**Sutherland Hospital Operating Theatre Upgrade (SSD-11099584)
Response to Submissions Report**

ATTACHMENT 1 – KEY ISSUES

# LANDSCAPE SECTIONS

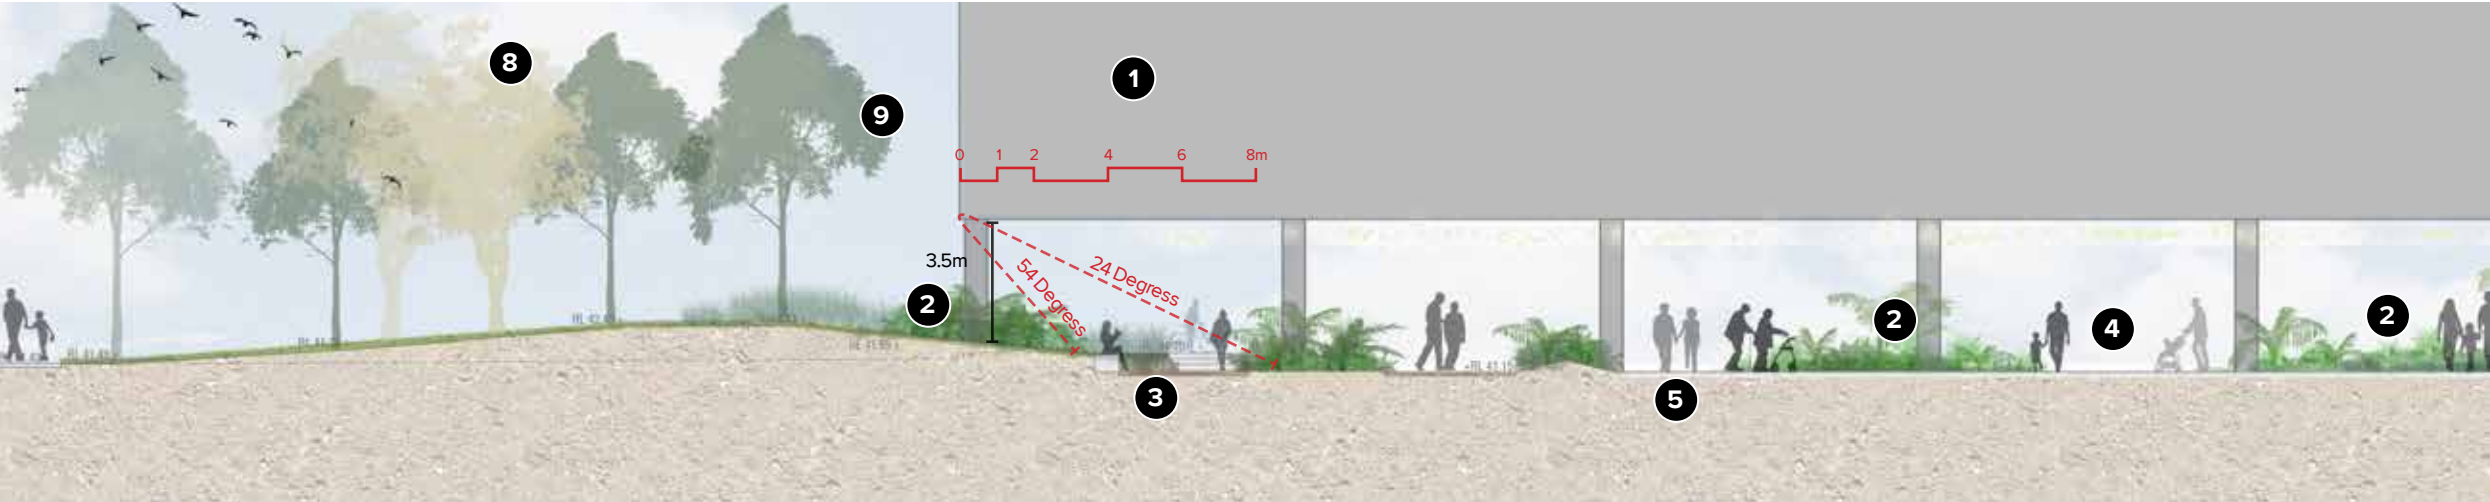
7. Updated architectural / landscape plans are to be submitted providing:
 - a) further clarity on the entrance to the hospital, in particular clarifying the main entrance and if the new entrance is for patients or the public.
 - b) provide a section view of the undercroft space including plans that illustrate the solar access to this space.

LOCATION PLANS

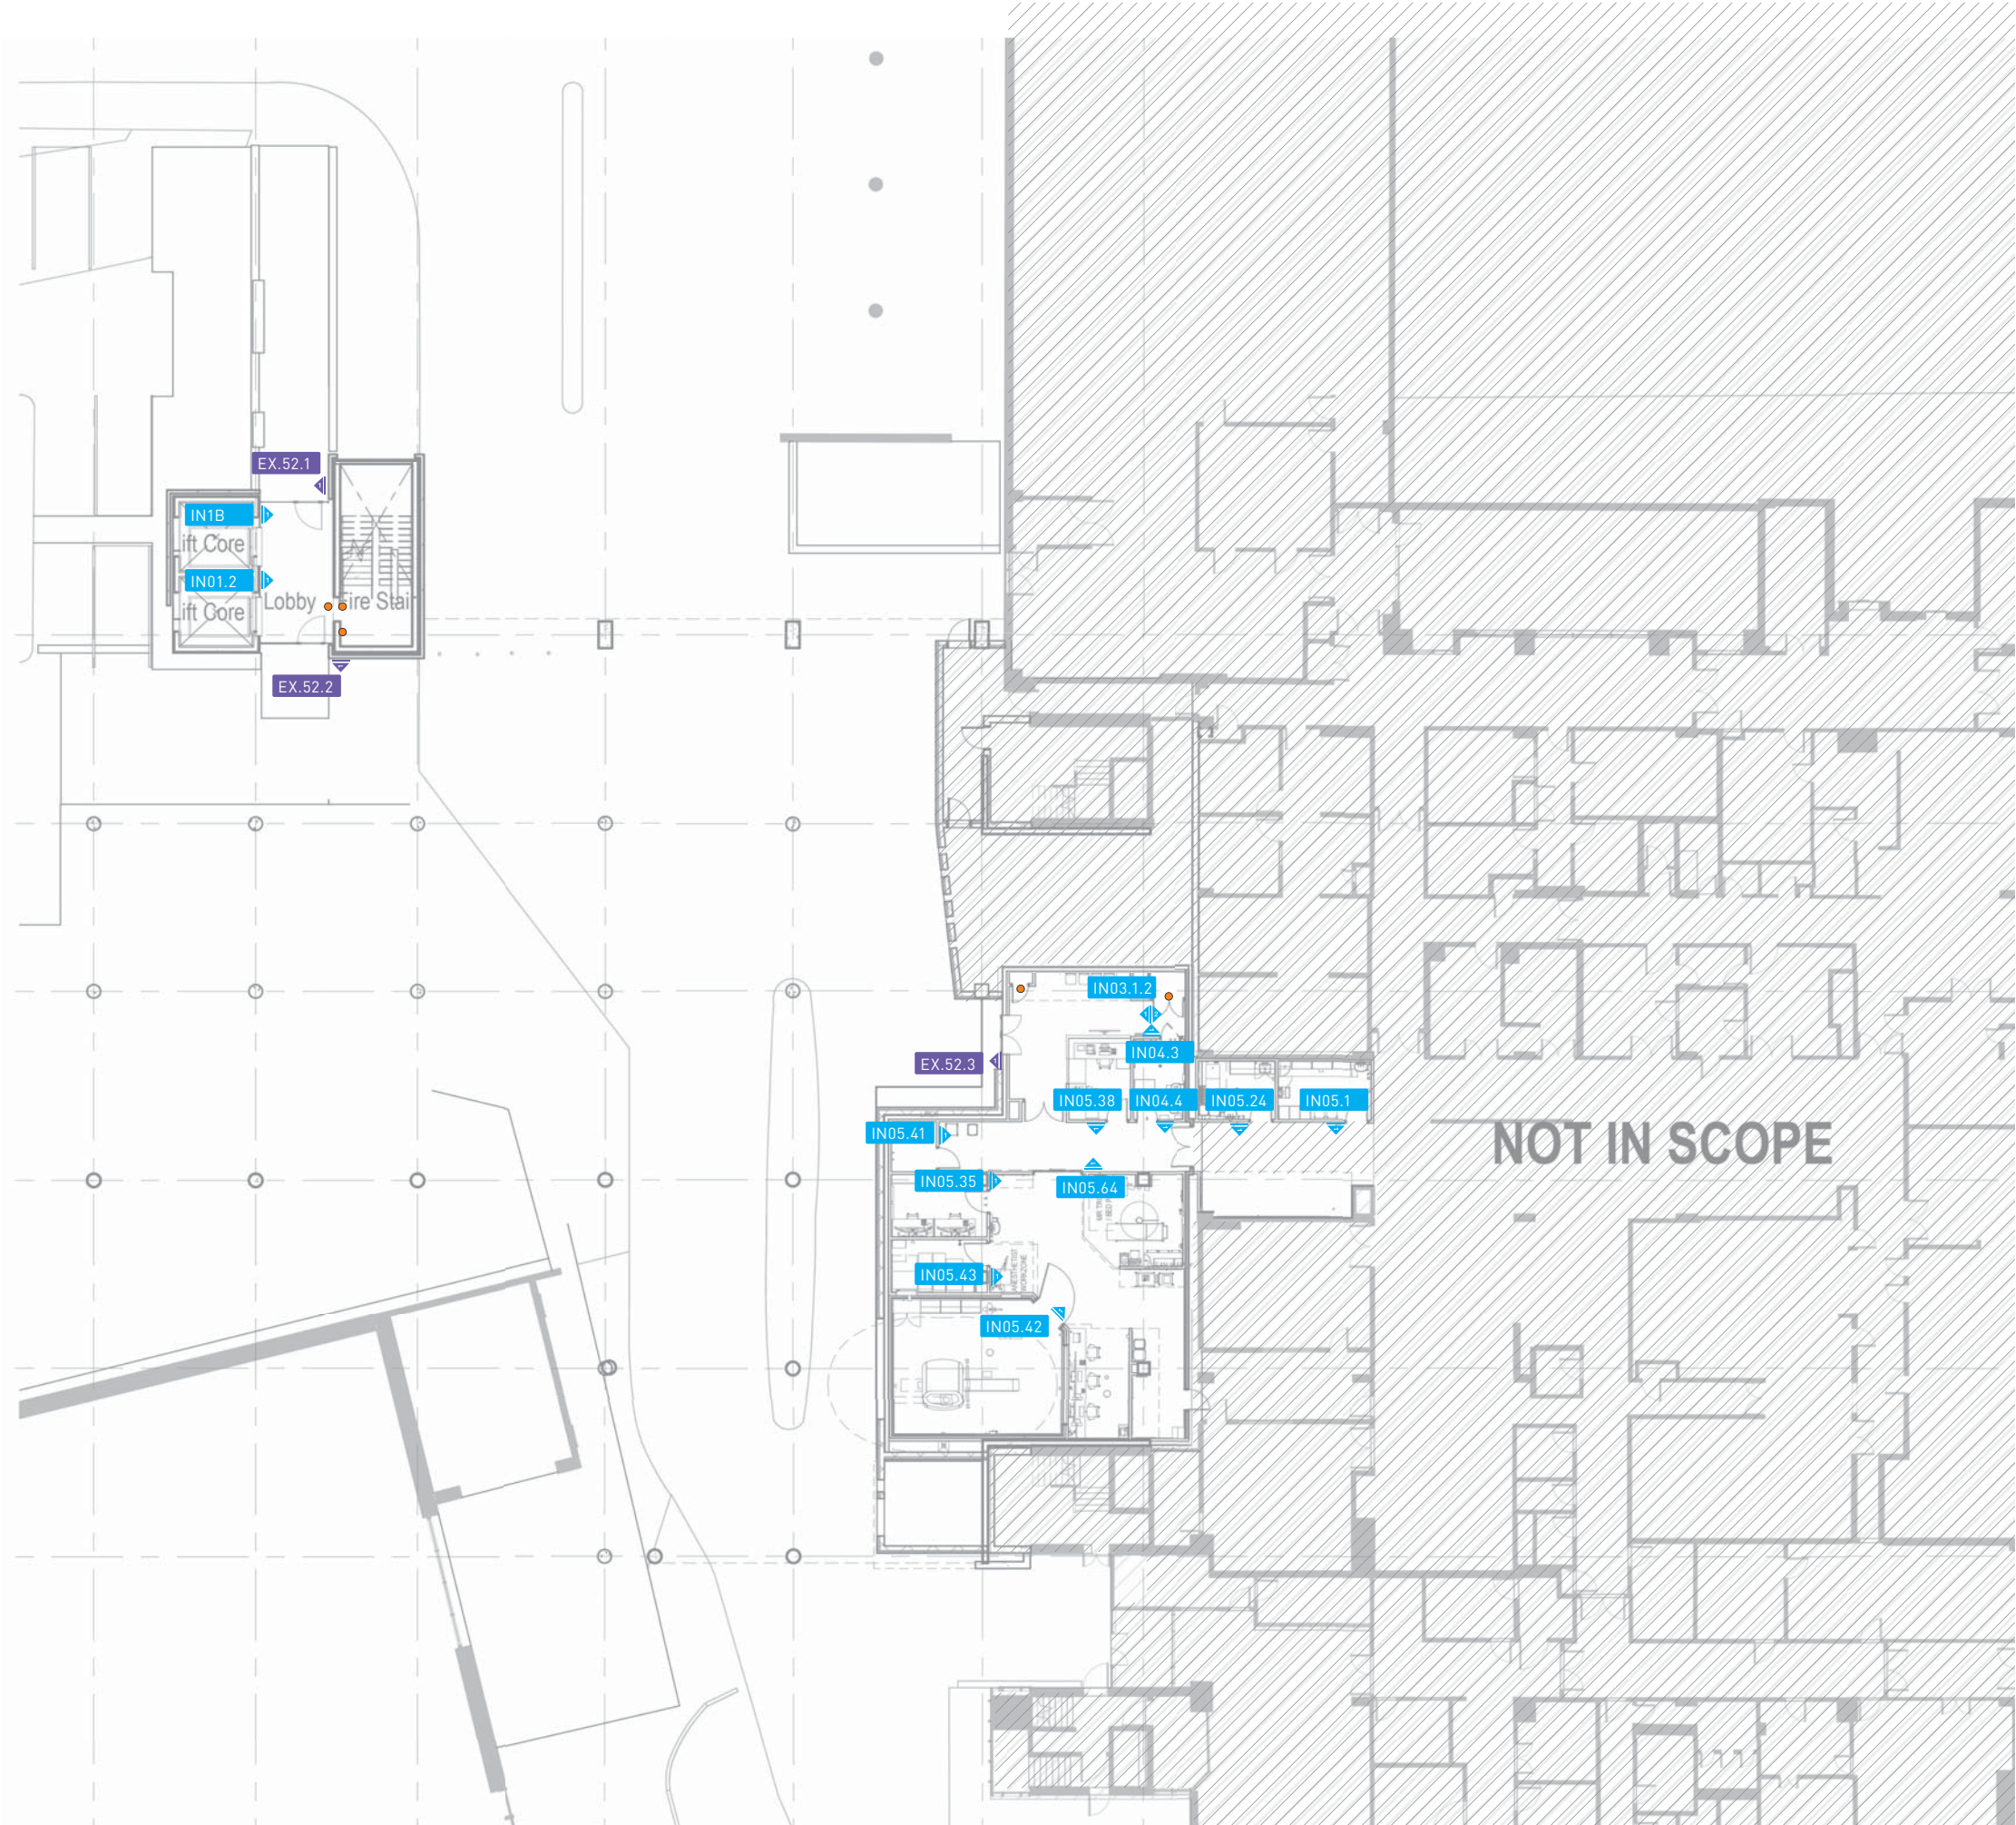
1. While the main hospital entrance is not being altered or changed in the proposal, the proposal also includes a smaller entrance, which may cause confusion when patients are entering the site. No signage has been included in this proposal but should be incorporated to improve wayfinding across the site.
2. No increase in bicycle parking or end-of-trip facilities are provided in this application. Clarification is to be provided on whether the existing facilities are sufficient for any increase in demand as a consequence of the proposed development.
